RE: SD-24-00001 & CU-24-00005, Red's Fly Shop
SR 821 (Canyon Road) milepost 14.67 Lt.

We have reviewed the proposed project and have the following comments.

SITE PLAN

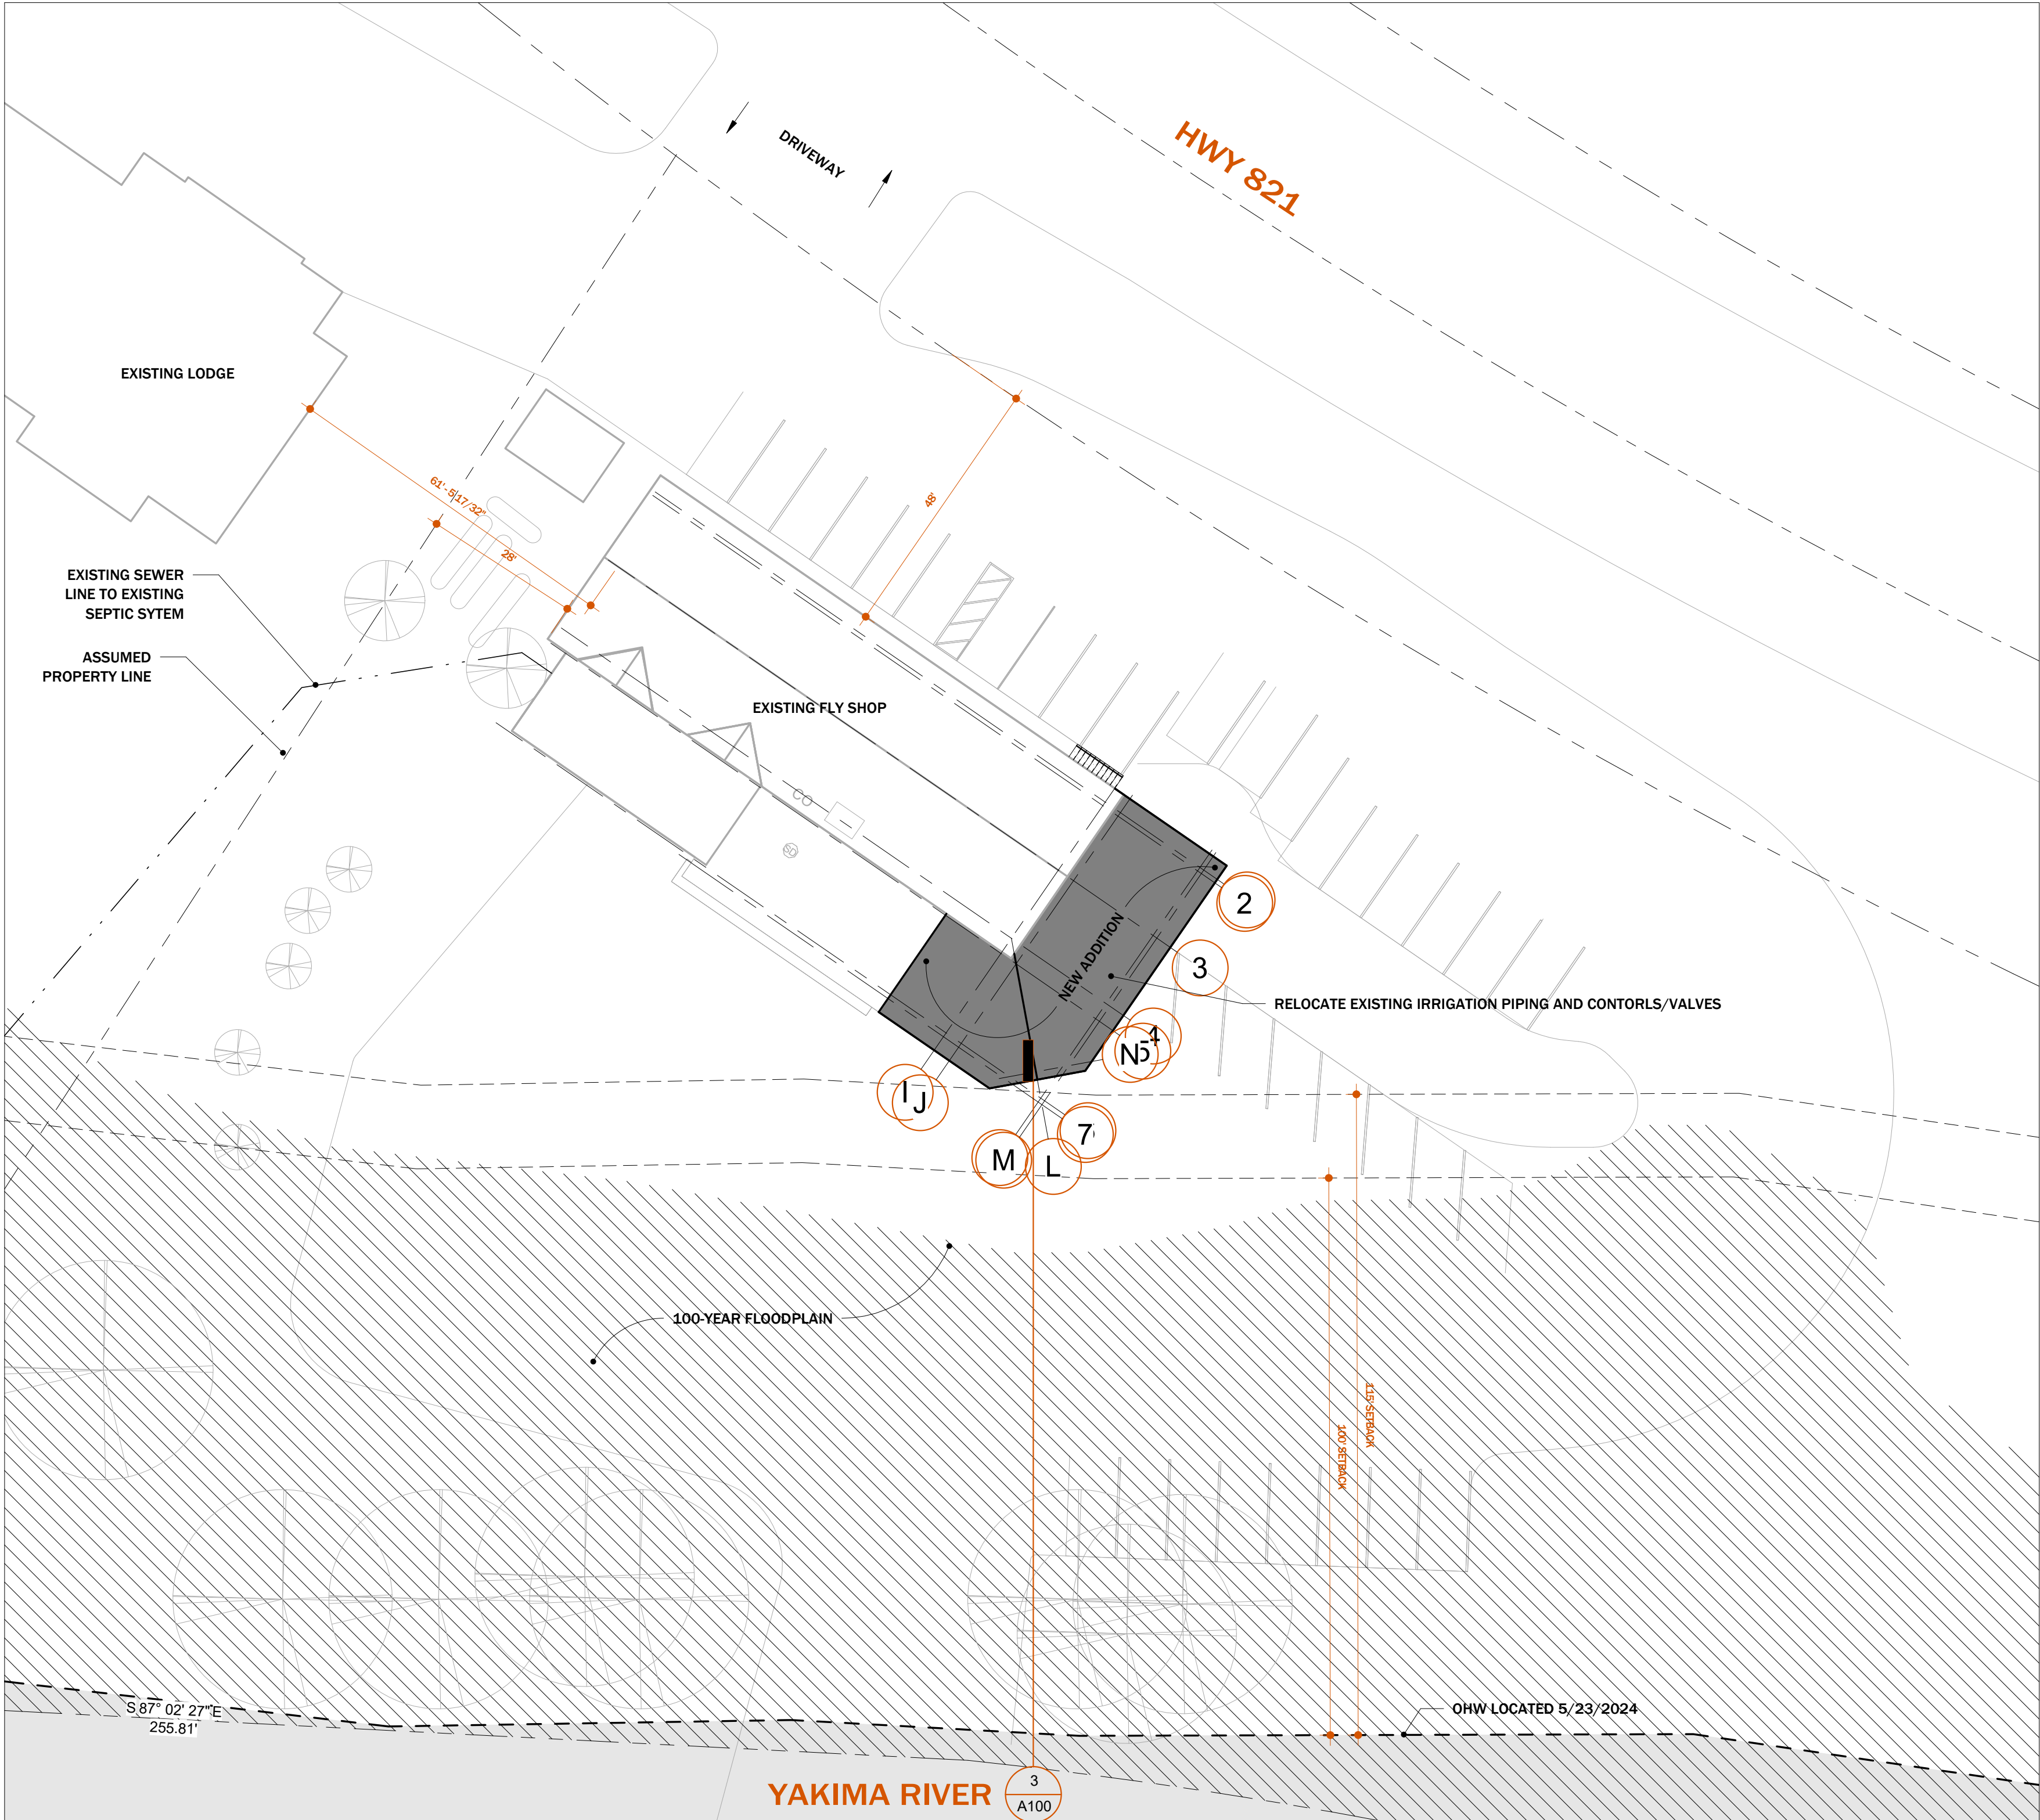
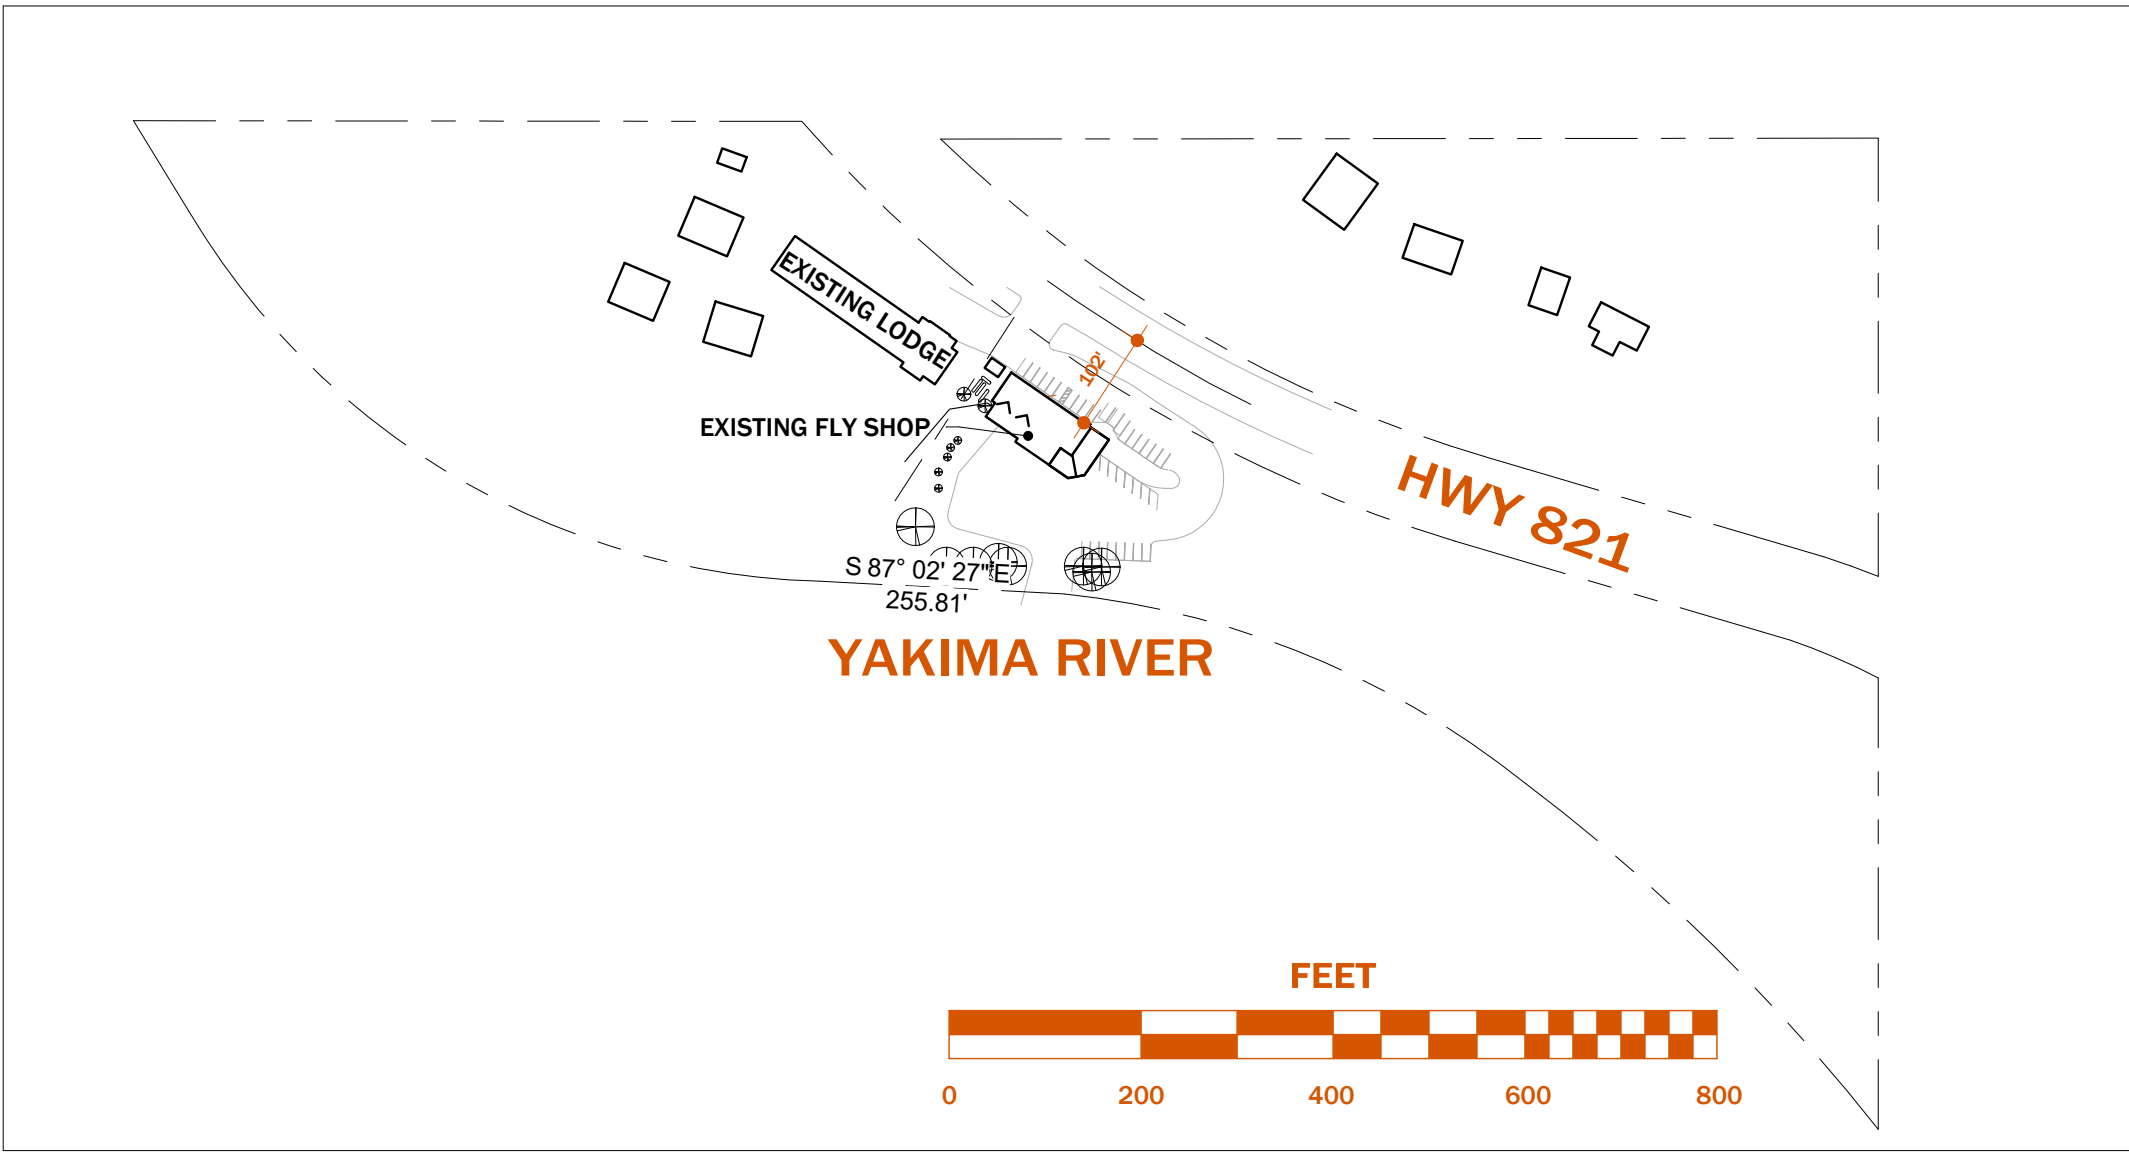
- The project is adjacent to State Route 821 (SR 821) also known as Canyon Road. SR 821 is a Class 3 access managed highway with a posted speed limit of 45 miles per hour. Currently, access to the property is via an existing permitted connection at mile post 14.67 Lt. (ACP 45865). This driveway can continue to serve this property; no additional access to the property will be allowed.
- Any proposed lighting should be directed down towards the site, and away from SR 821.
- Any signs that may be proposed as part of this project will need to comply with the state Scenic Vistas Act of 1971 (RCW 47.42 and WAC 468-66). Please contact Tanya Joblonski of the WSDOT Headquarters Traffic Office for specifics. She can be reached at (360) 705-7294.
